DEVELOPMENT REVIEW BOARD  
**SUPPLEMENTAL SUBMITTAL**

PROJECT NO. 2020-004475  
Application No. SI-2021-00254

SUBMITTAL  
DESCRIPTION: Dental office for Pino Periodontics. This submittal includes the responses to all the staff comments.

**RE: Pino Periodontics dental office development at 7413 Holly Ave NE.**

A NEW DENTAL OFFICE FOR:
PINO PERIODONTICS
CURTIS PINO, DDS, MSD
7413 HOLLY AVENUE, NE
ALBUQUERQUE, NM

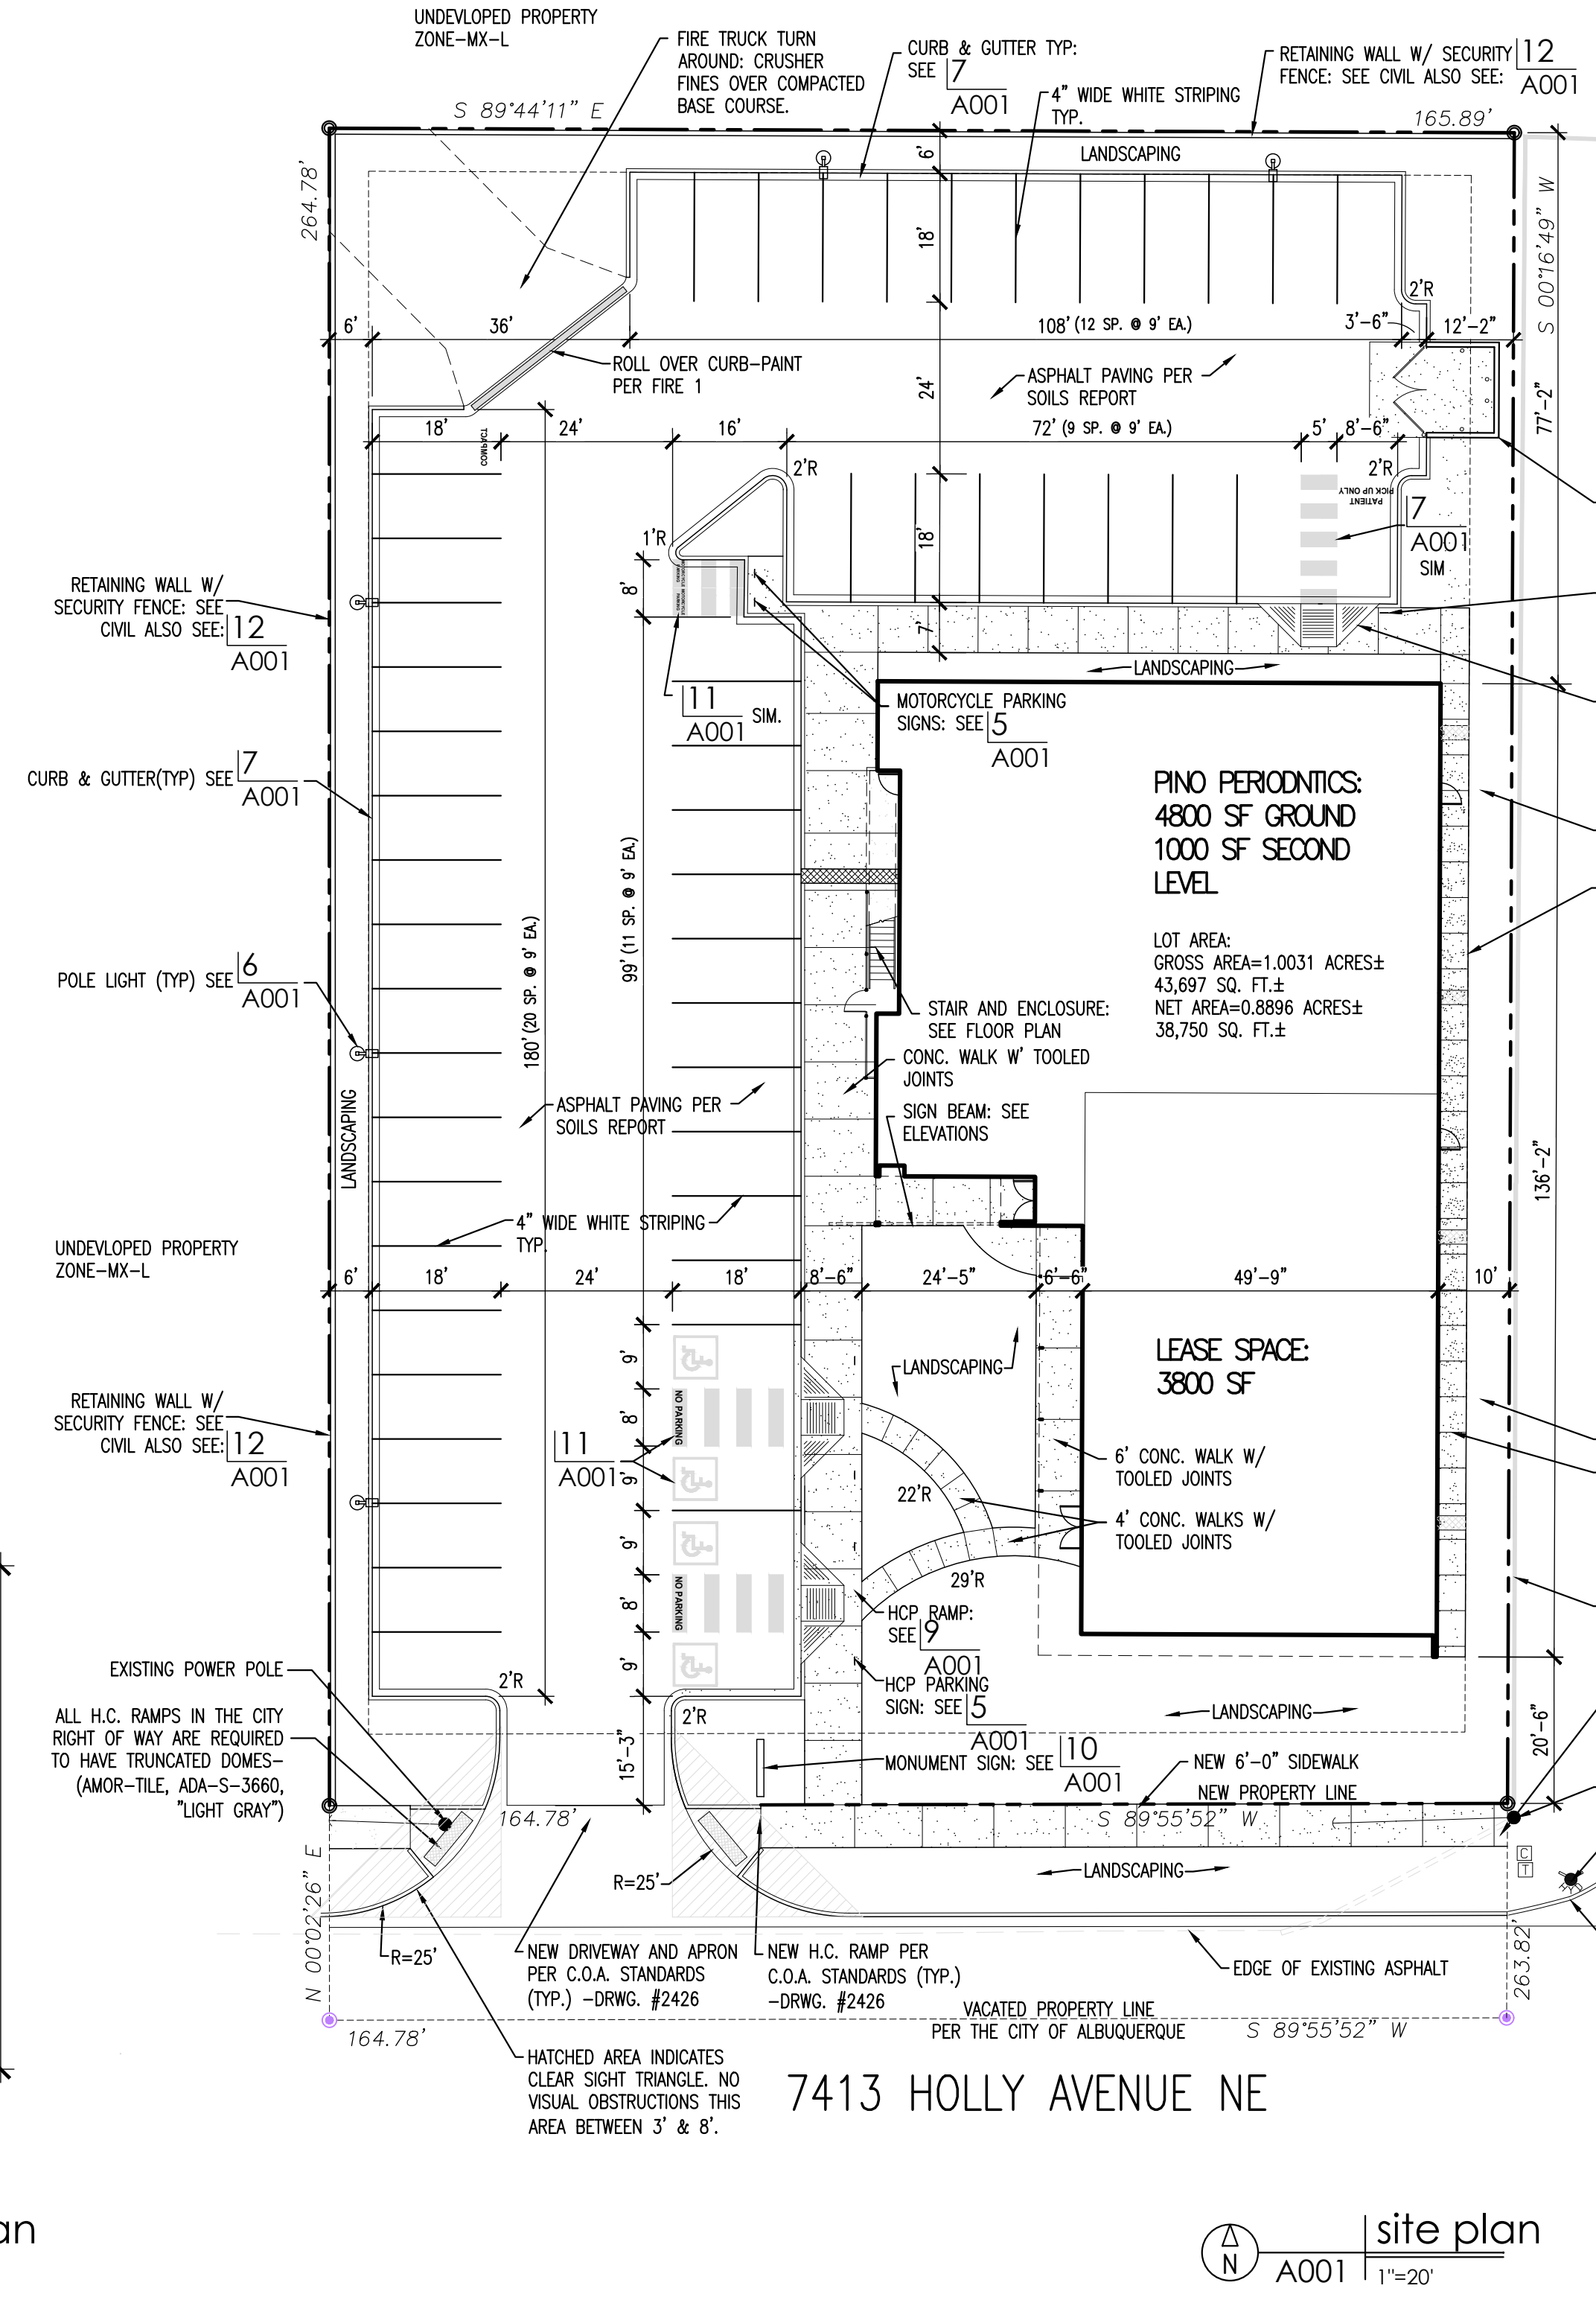
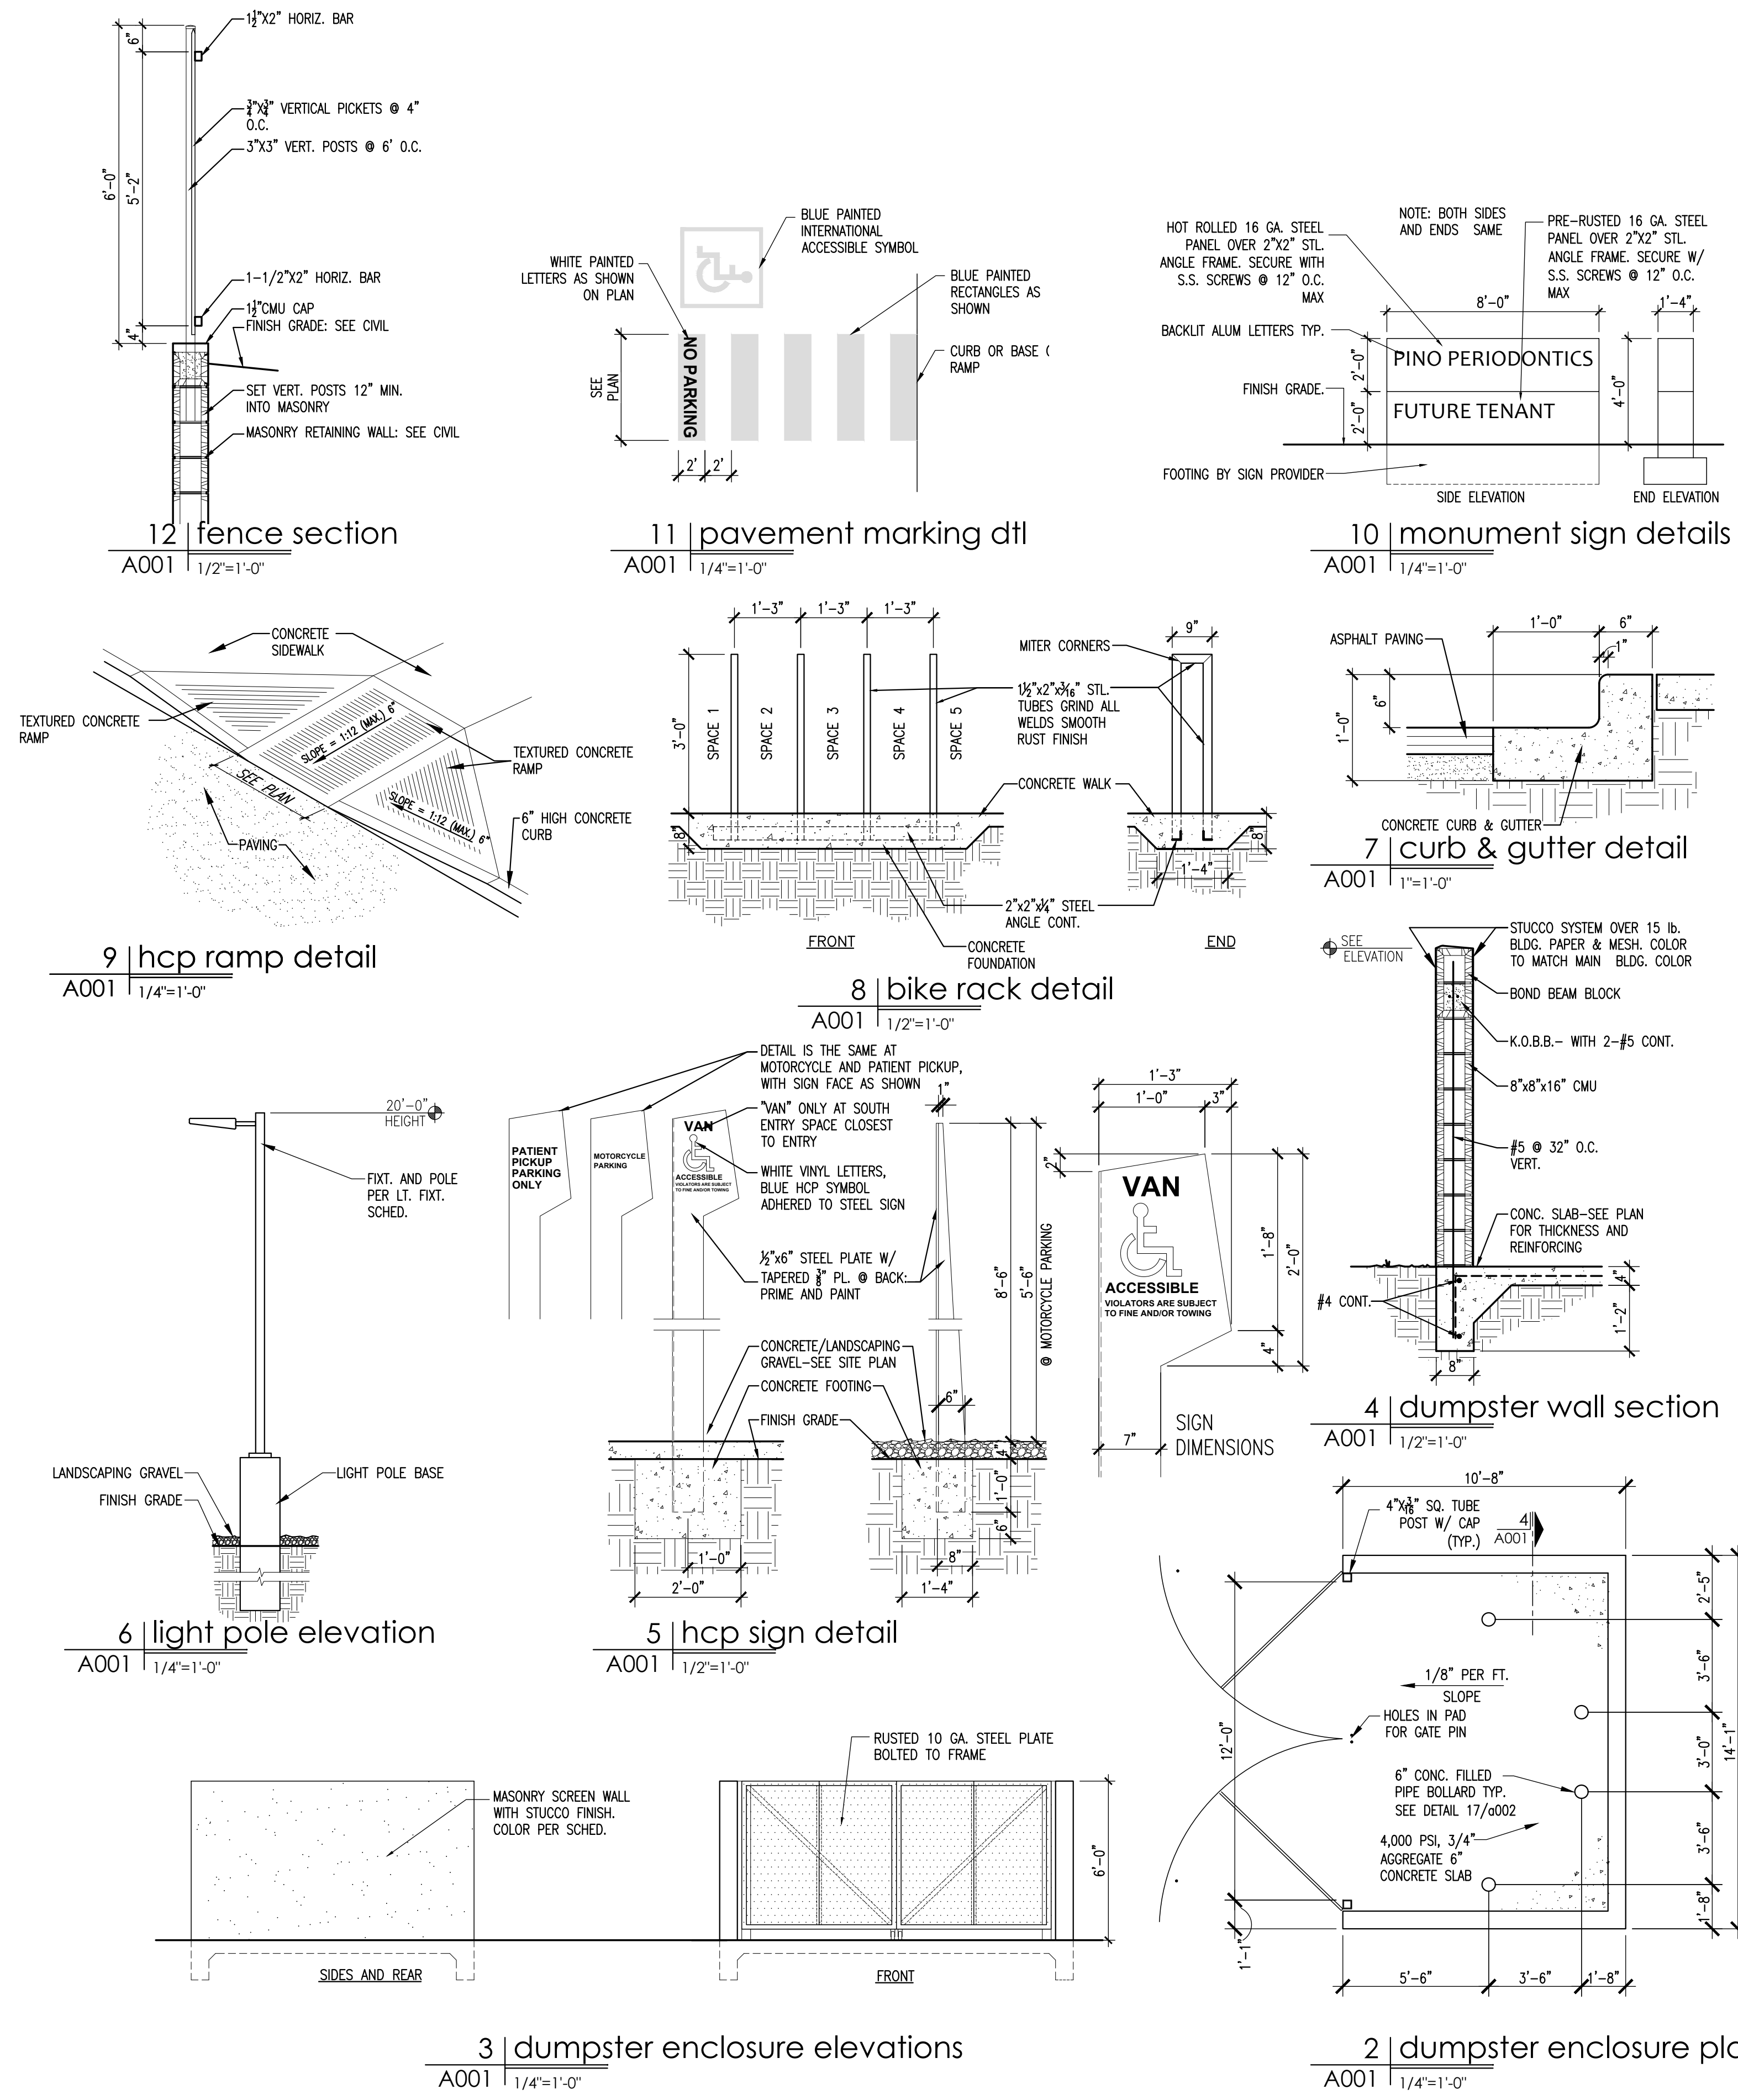
3. **Curbs and sidewalk cross slope:** Curb and gutter locations are indicated on the site plan. Detail 7/A001 shows the curb and a note has been added "At sidewalk locations cross slope shall not exceed 2%." Also, a note has been added in three locations on the site plan "SIDEWALK NOTE: CROSS SLOPE AT SIDEWALKS SHALL NOT EXCEED 2% GRADE, TYP."

4. **Motorcycle Parking:** The motorcycle spaces have "MOTORCYCLE PARKING" shown to be painted on the parking spaces and vertical signs are also shown at the front of the spaces. Detail 5/A001 refers to the signs.

5. **Bike Rack:** a bike rack is now shown on the site plan and referred to detail 8/A001
6. **Hcp Parking signs:** Handicap parking signs are shown at each of the four hcp parking spaces and referred to detail 5/A001.
